Arun District Council
Planning Department
Maltravers Drive
Littlehampton
West Sussex
BN17 5LF

Re: Planning Application R/175/12 - No. 46 Seafeld Road, Rustington, BN16 2JQ

SCHEMATIC OF N° 46 TO BE DEMOLISHED 1/200

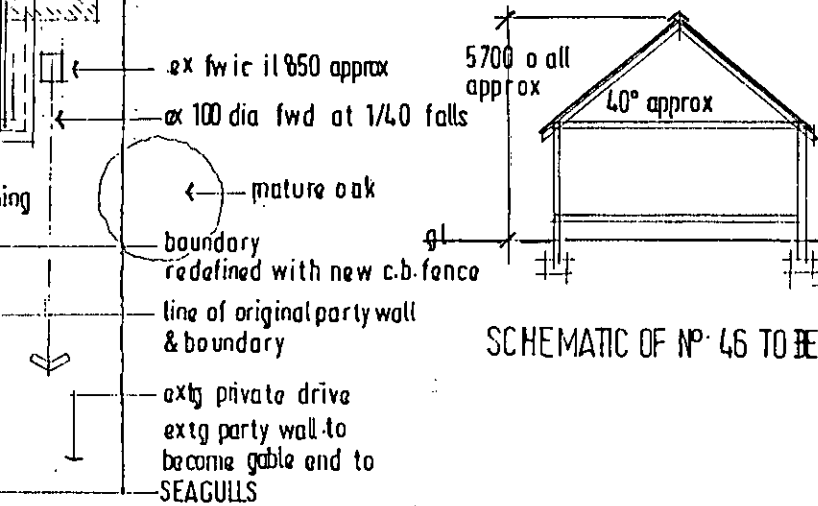
2. The drawing of the existing building cannot be correct in that it creates the impression that the existing four bedroom dwelling is being replaced with a new four bedroom dwelling. The drawing of the existing dwelling has no kitchen and so in fact it is at most a three bedroom dwelling. It is interesting to note that the GIA (Gross Internal Area) of the proposed dwelling is in excess of 2,050ft² compared to the existing dwelling which has a GIA of approximately 650ft². Interestingly the Ground Floor GIA comparison is 1190ft² for the proposed dwelling compared with 650ft² for the existing dwelling, a 68% increase in footprint. The overall increase in GIA for both floors of the proposed dwellings compared with the existing dwelling represents a 215% increase in area. Quite simply this demonstrates that the proposal is inappropriate and, as mentioned above, is an overdevelopment of the small site.

BLOCK PLAN 1/500

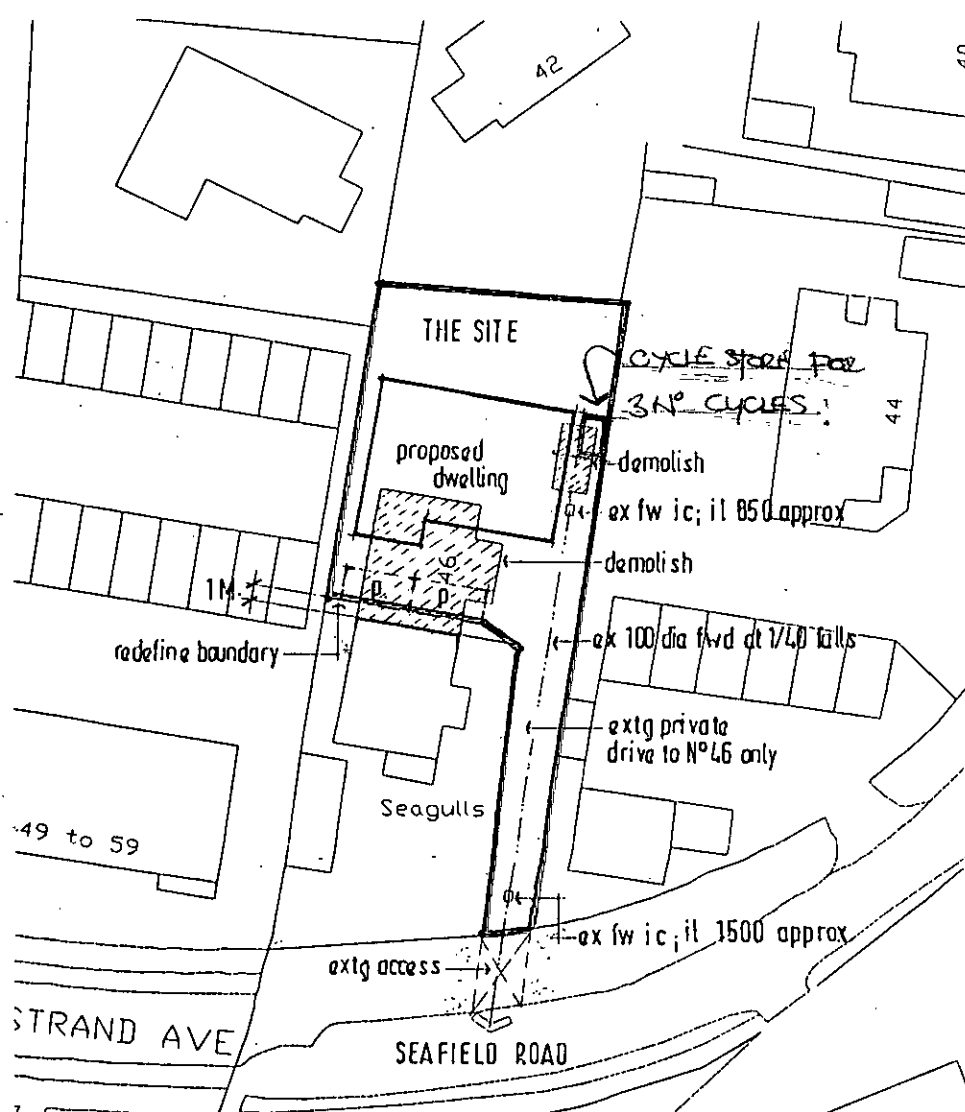
1. The development in our opinion is an overdevelopment of the current site in relation to the surrounding buildings. The existing building is a relatively semi-detached single storey retirement/ holiday bungalow whereas the proposed development is a large detached two storey family home which is built tight to the West and East boundaries and leaves little space to the front or rear (South and North) of the site. It is evident that the mass of the development is inappropriate when compared with the surrounding area.

SECTION A : A 1/100

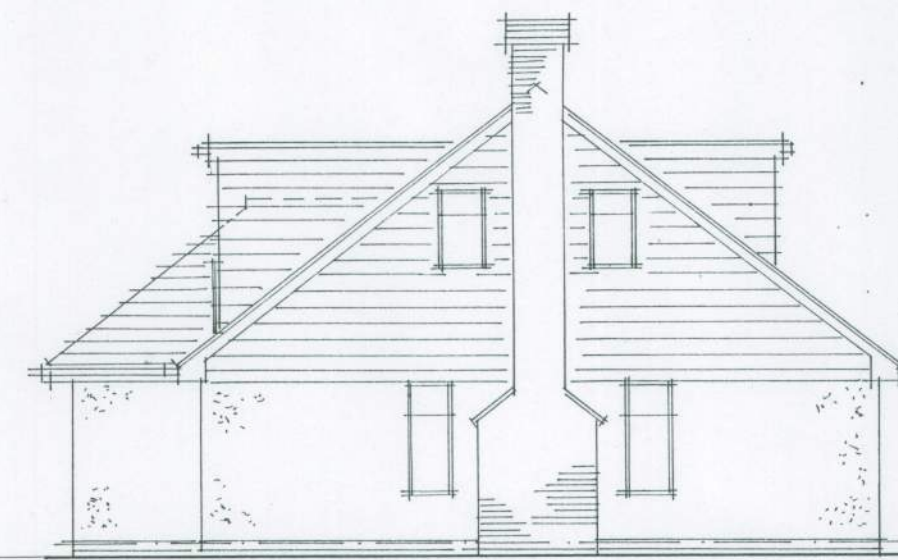
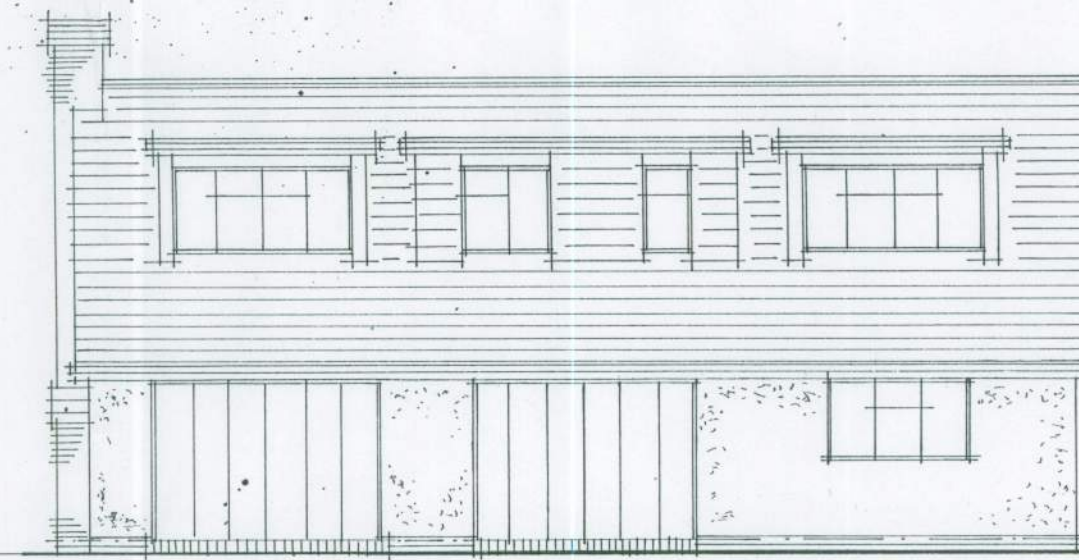
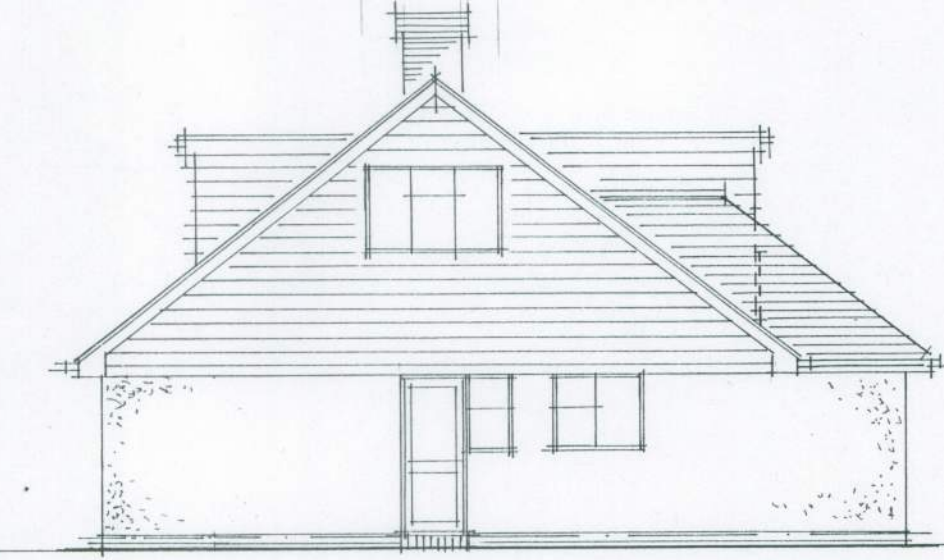
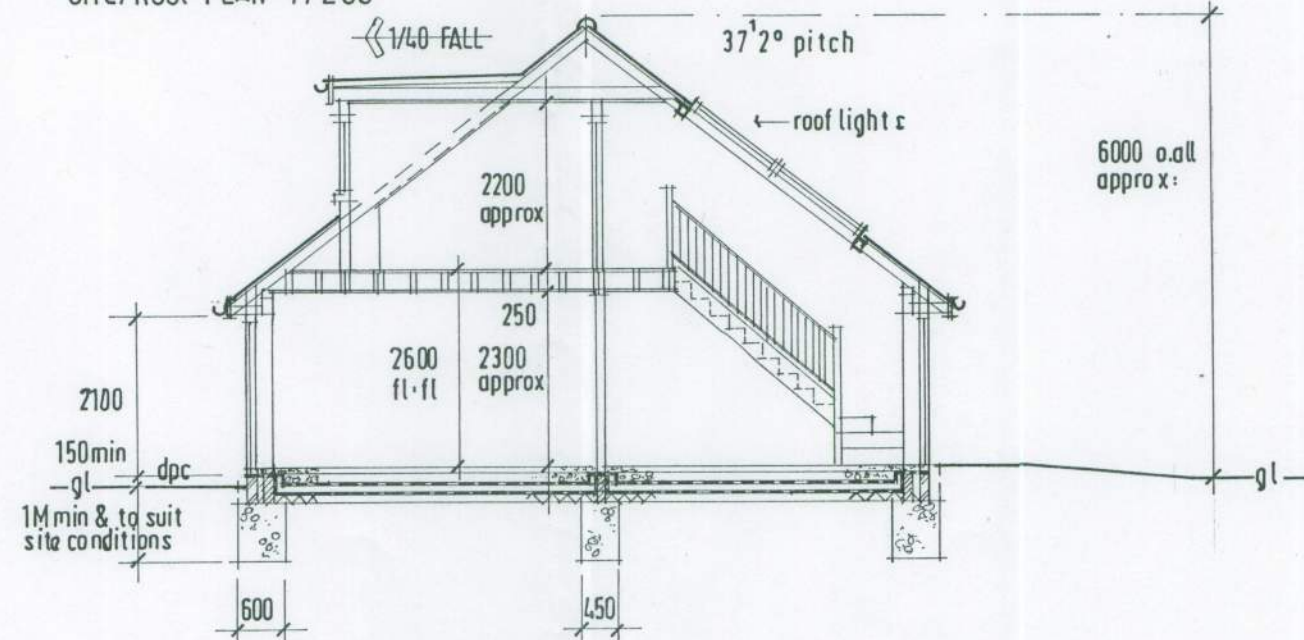
3. Apart from the positioning of the proposed dwelling on the site we are concerned that the ridge height of the proposed dwelling is 6.00M when compared with the existing dwelling height of 5.70M.
